Grazing Yak Solar

El Paso County, Colorado

Re-Seeding Plan

SHEET: PL.01

SHEET: PL.01

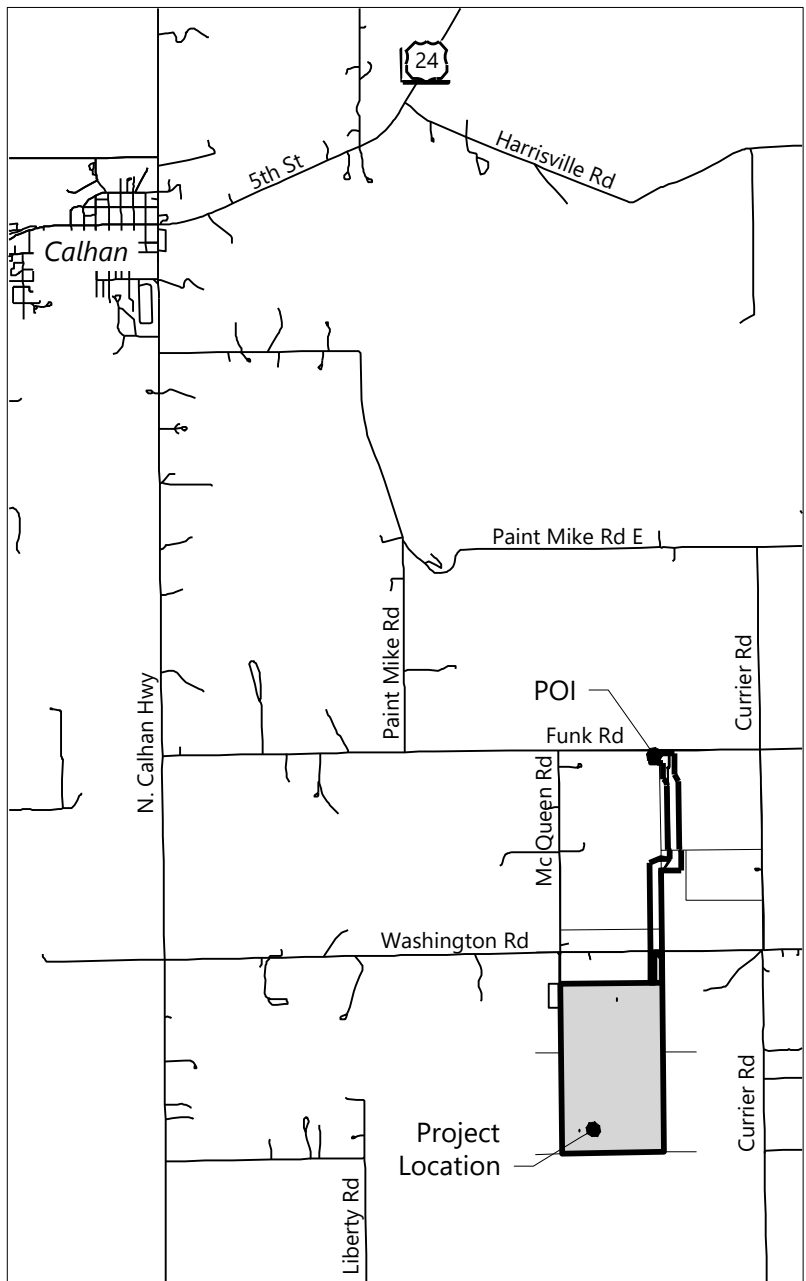
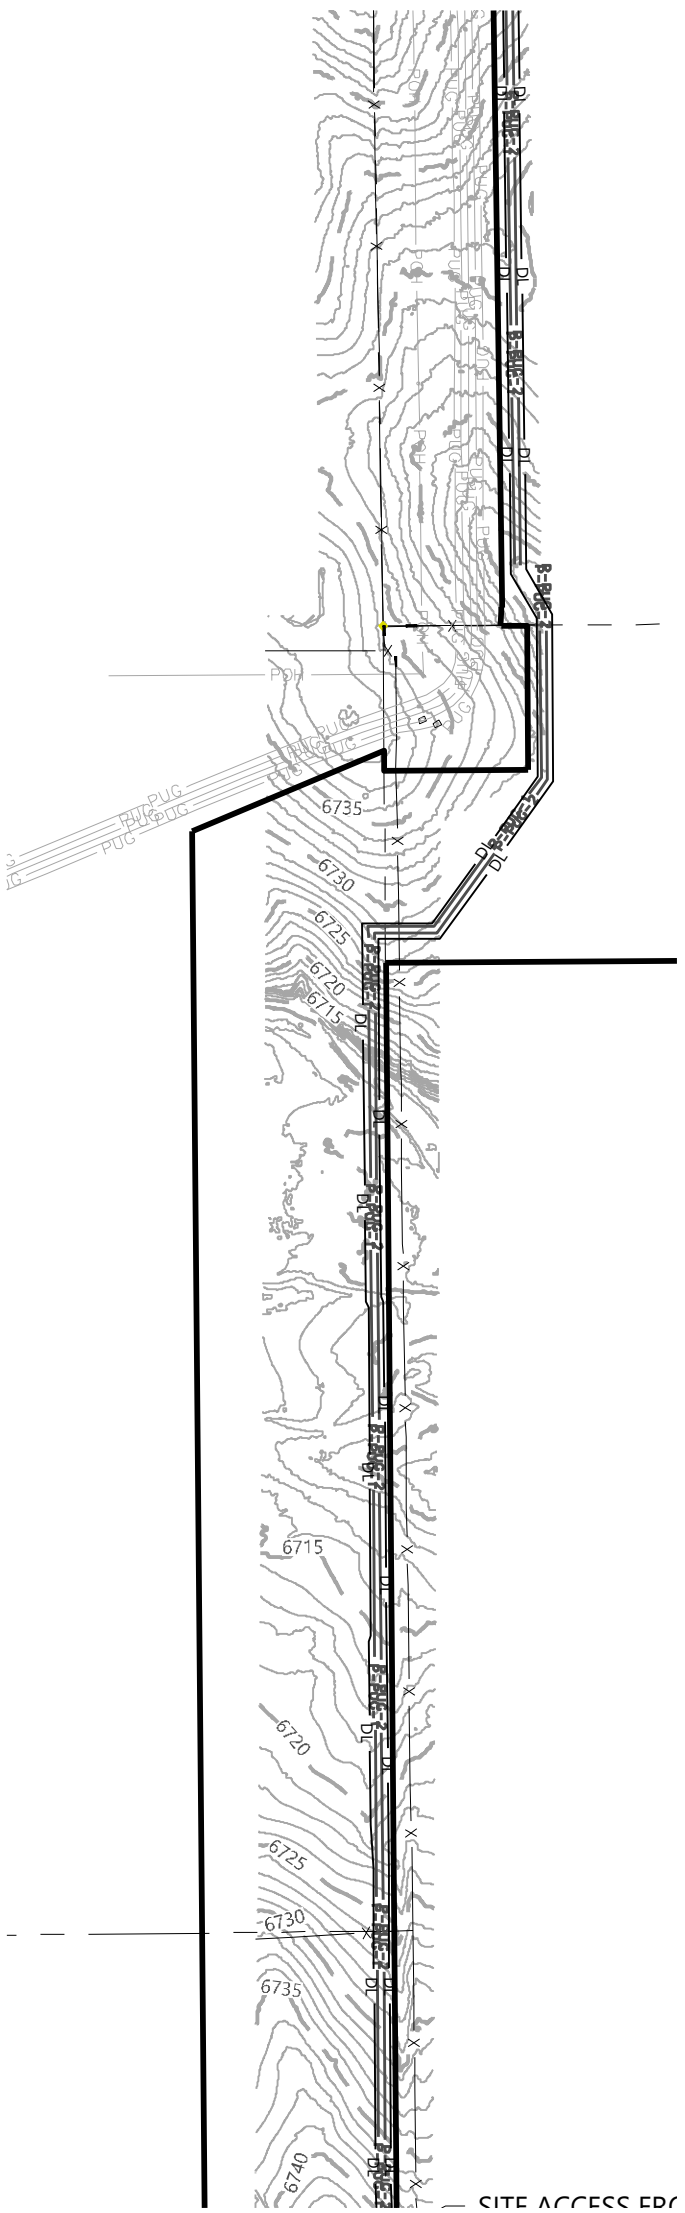
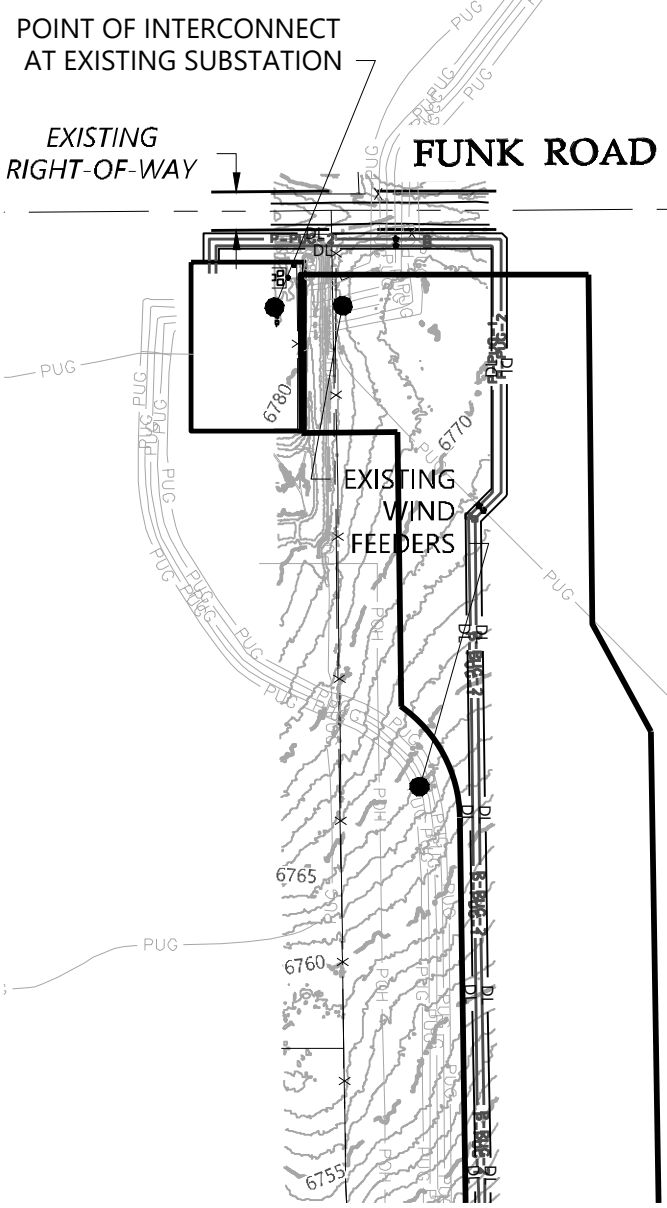
Specify mix(s) and methods include, blanket, watering plan etc... The details must be provided.

Include in the FAE

Identify these setback, fence re-seeding, boundary lines with a leader; it is not clear what lines are which.

This plan is not legible due to the scale

Identify reclamation plan for this area on sheet
